Portland Harbor Hotel Addition

MEMORANDUM

Subject: Application ID: 2007-0089

Date: 9/7/2007

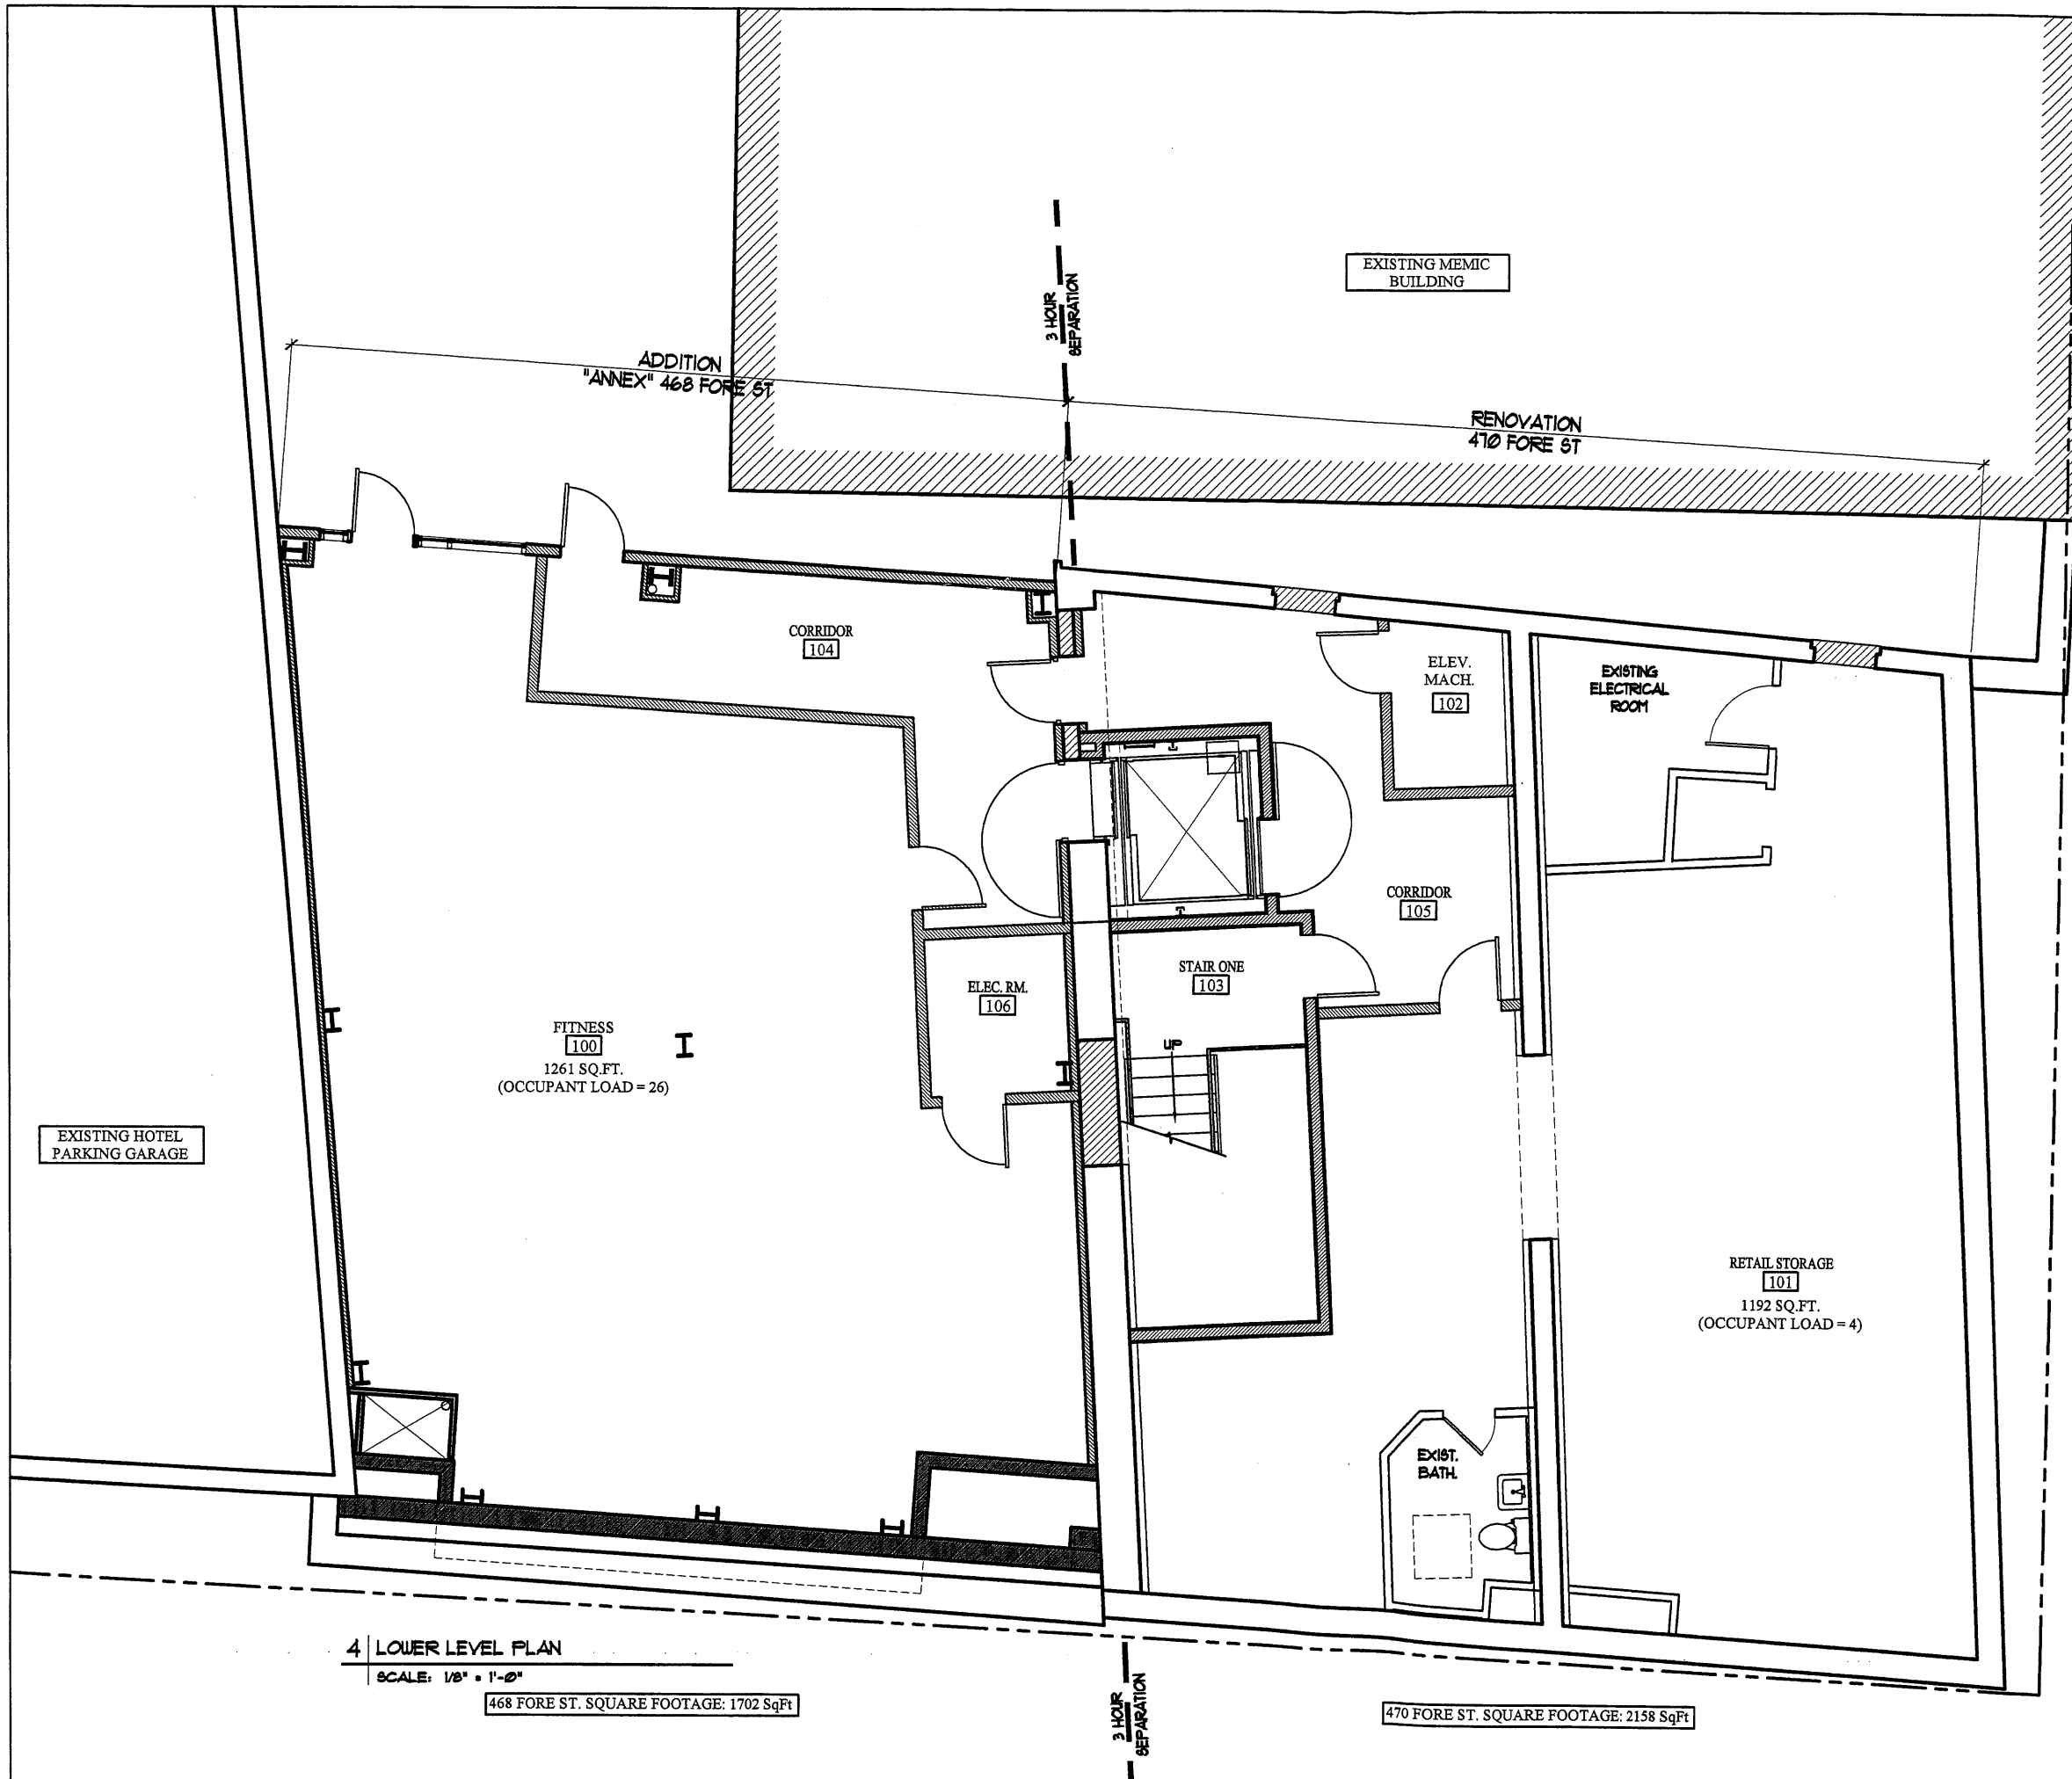
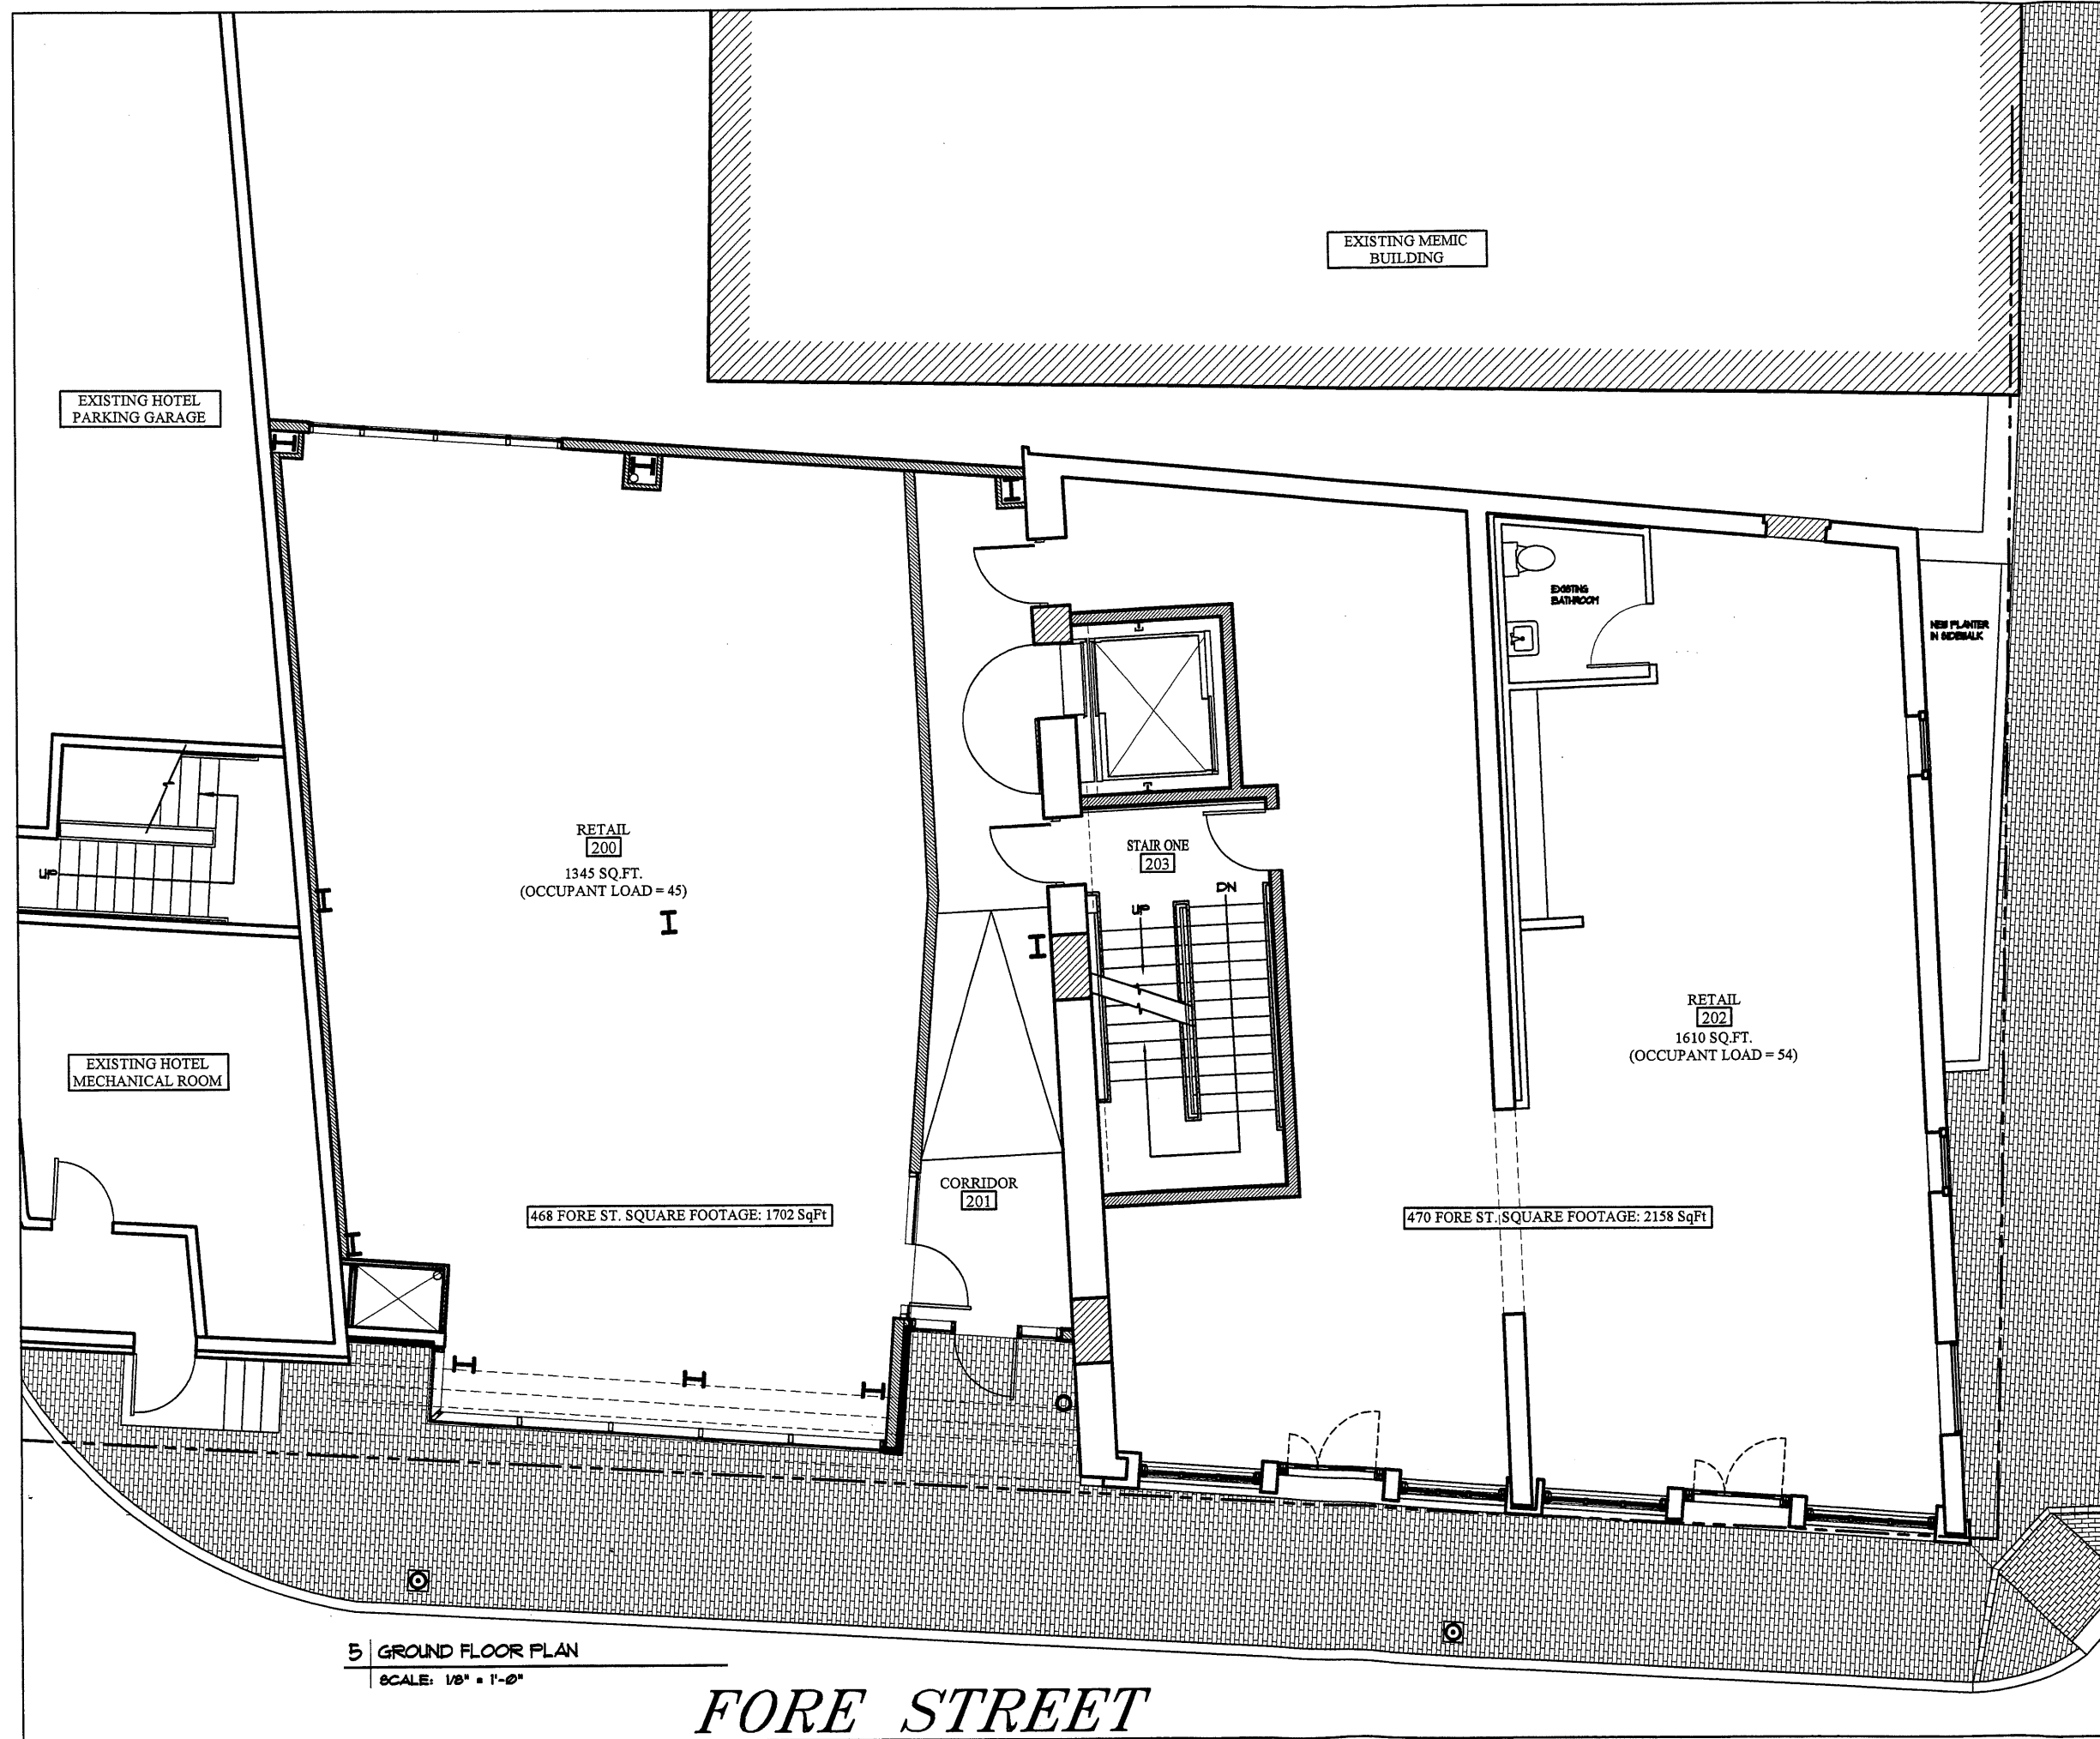
I have reviewed the floor plans received on August 29, 2007. My parking analysis of the new structure would require an additional 16 parking spaces. The parking study submitted on 5/31/2007 shows the existing parking capacity for the 16 addition parking spaces.

I have reviewed the basic submittal. I have noted that there are no floor plans to help determine uses and parking requirements. I do not agree with the methodology used to create the submitted parking analysis. The old Akari building was determined to be all retail in its past use. It was only partial retail with personal services throughout the upper floors. The wrong numbers from the parking section of the ordinance were used in this analysis. This being said, I agree with the bottom line that there is apparently a parking surplus that the proposed structure on site can use. I believe that the parking requirements are being met with this proposal. Only the new structure generates parking requirements. The change of use of the existing Akari building does not need to meet the parking requirements based upon the B-3 zone parking allowances.

I would like to see floor plans of the new structure and for the rehabbed Akari building to quantify the number of hotel rooms in total proposed.
